City of Portland, Maine - Building or Use Permit Application
 389 Congress Street, 04101 Tel: (207) 874-8703, Fax: (207) 874-8716

Permit No: 05-1805	Issue Date:	CBL: 298 B041001
------------------------------	--------------------	----------------------------

Past Use: Single Family	Proposed Use: Single Family change of use for home occupation / Imported goods	Permit Fee: \$30.00	Cost of Work: \$225.00	CEO District: 5
Proposed Project Description: Change of use for home occupation / Import goods		FIRE DEPT: <input type="checkbox"/> Approved <input type="checkbox"/> Denied	INSPECTION: Use Group: Type	
		Signature:	Signature:	
PEDESTRIAN ACTIVITIES DISTRICT (P.A.D.)				
Action: <input type="checkbox"/> Approved <input type="checkbox"/> Approved w/Condition <input type="checkbox"/> Denied				
		Signature:	Date:

FLOOR PLAN

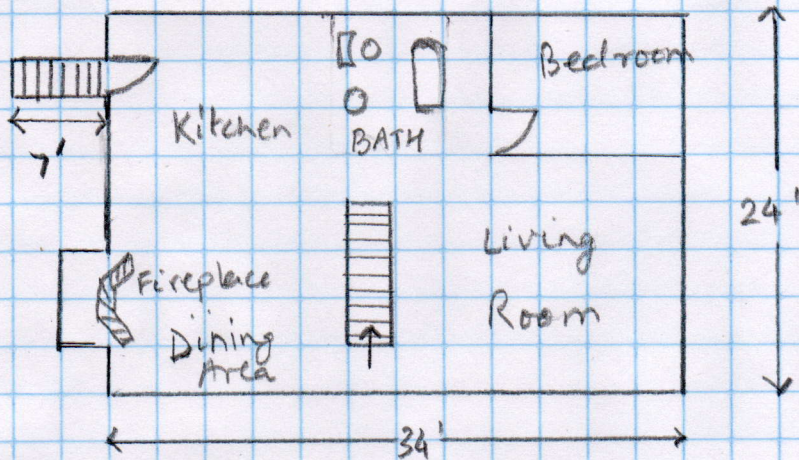
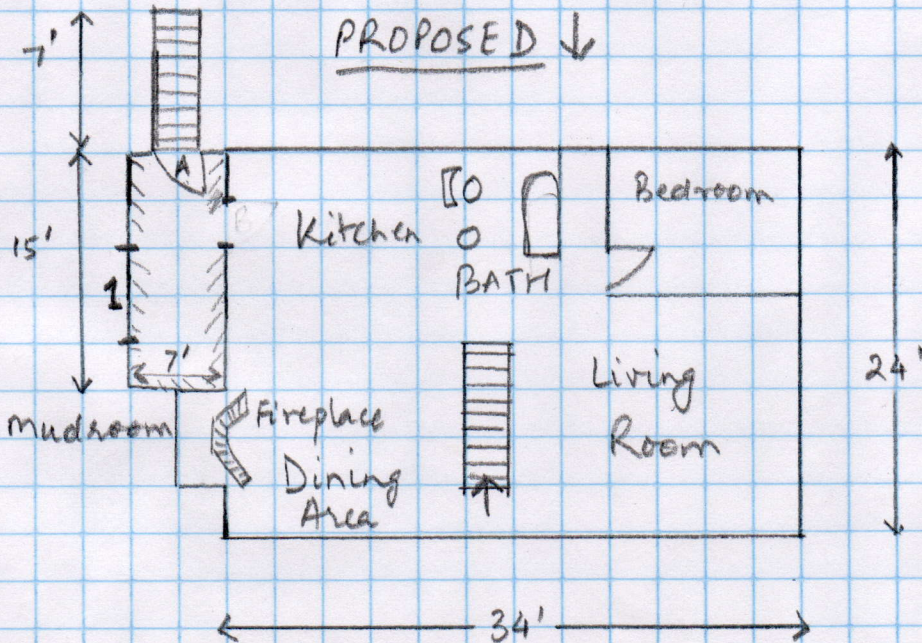
12/16/05-amachado: I left a message with InduBala Gupta. She needs to give us more complete dimensions of the home occupation area and more detail about exactly how that space will be used.

- 1) This permit is being approved on the basis of plans submitted. Any deviations shall require a separate approval before starting that work.
- 2) During its existence, all aspects of the Home Occupations criteria, Section 14-410, shall be maintained.
- 3) Separate permits shall be required for any new signage based on the guidelines for signs in section 14-410.
